From: Kathryn Welch
Sent: 29 June 2026 15:23
To: Planning Scanning
Subject: FW: Highdown Garden Centre - Proposed Canopies

From: Graeme Jones [REDACTED]
Sent: 12 June 2026 18:15
To: Kathryn Welch <Kathryn.Welch@arun.gov.uk>
Cc: Chris Primett <[REDACTED]> Luke Whitehall [REDACTED] George Lisher [REDACTED]
Subject: Highdown Garden Centre - Proposed Canopies

The planning application for Highdown has been positively received by everyone and it would be a great shame if drainage continues to be the only stumbling block particularly when the scheme will without doubt offer massive betterment to the existing drainage of canopy and external sales, it has got to be in the public interest to agree a practical solution. We have answered the limited response to our last submission in the attached document where we have added your Engineer's last comments in red and ours in purple but I want us to try avoid the drainage becoming even more protracted so will summarise the most salient points where we are and hopefully you can get this last item over the line.

Drawing No: A9803 - 140 P2

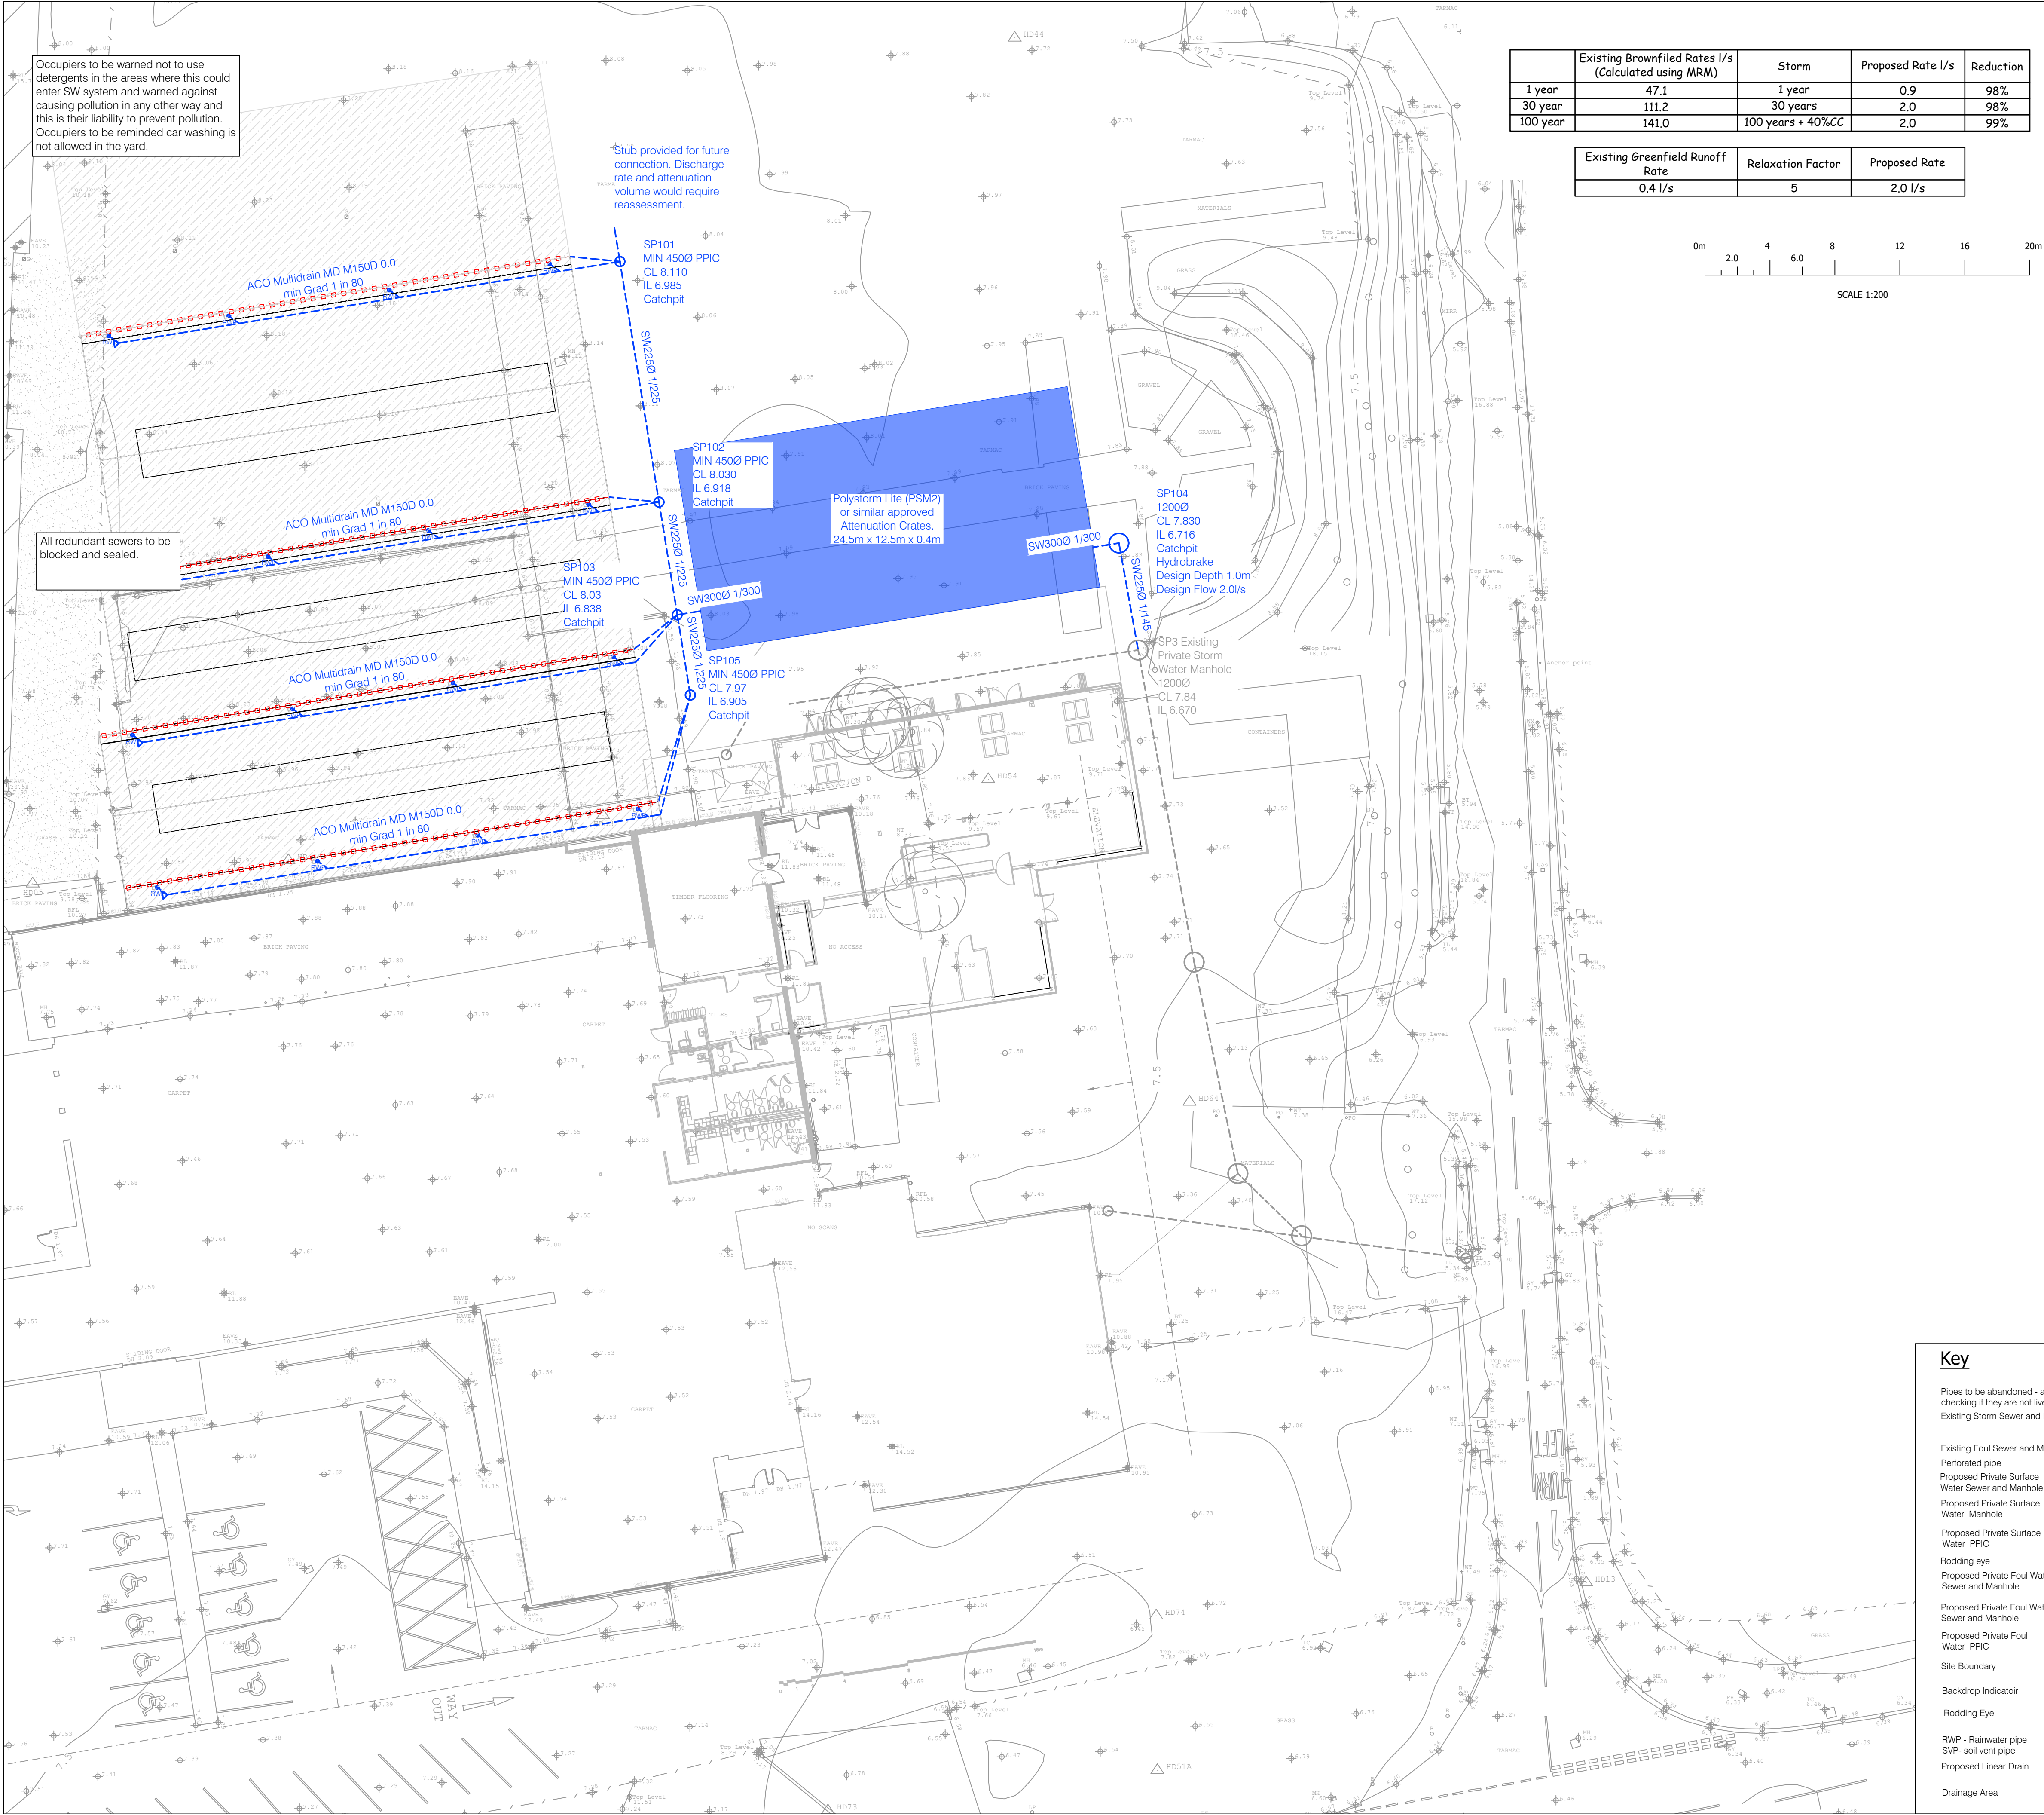
- Firstly, we are not sure whether your Engineer has received and reviewed all the information we have sent, since there are quite a lot of sections that have no comments and they are not referenced on page 2, but really want to concentrate on the crux below

- In response to our very detailed explanation of reuse of rainwater your engineer has requested that some reuse of rainwater should be incorporated and the only practical solution for us would be to introduce some water butts, and we would like to offer that as a fair compromise.

- We previously issued a lot of information about the ground conditions and reasoning why the attenuation is the only viable route including a borehole for the existing ground conditions .

- Please bear in mind that we have physically built on site and carried out 2 m deep Building Regulations Percolation test witnessed by our Site Manager and Client which completely failed. 2m depth being used for standard soakaways.

- Our Chartered Engineer has reviewed the comments on revised drainage scheme and wondered again whether your Engineer has been given the full revised design package which addressed his initial concerns. The drained area is shown crossed hatched on the drawing. Design peak discharged is agreed. Both the flow rate calculations and the greenfield runoff rate have total impermeable area of 0.149ha so we do not understand where you have a mismatch. We enclose the same drawing confirming the area and the calculations again. As far as we are concerned, this revised scheme is compliant as produced by our Chartered Drainage Engineer
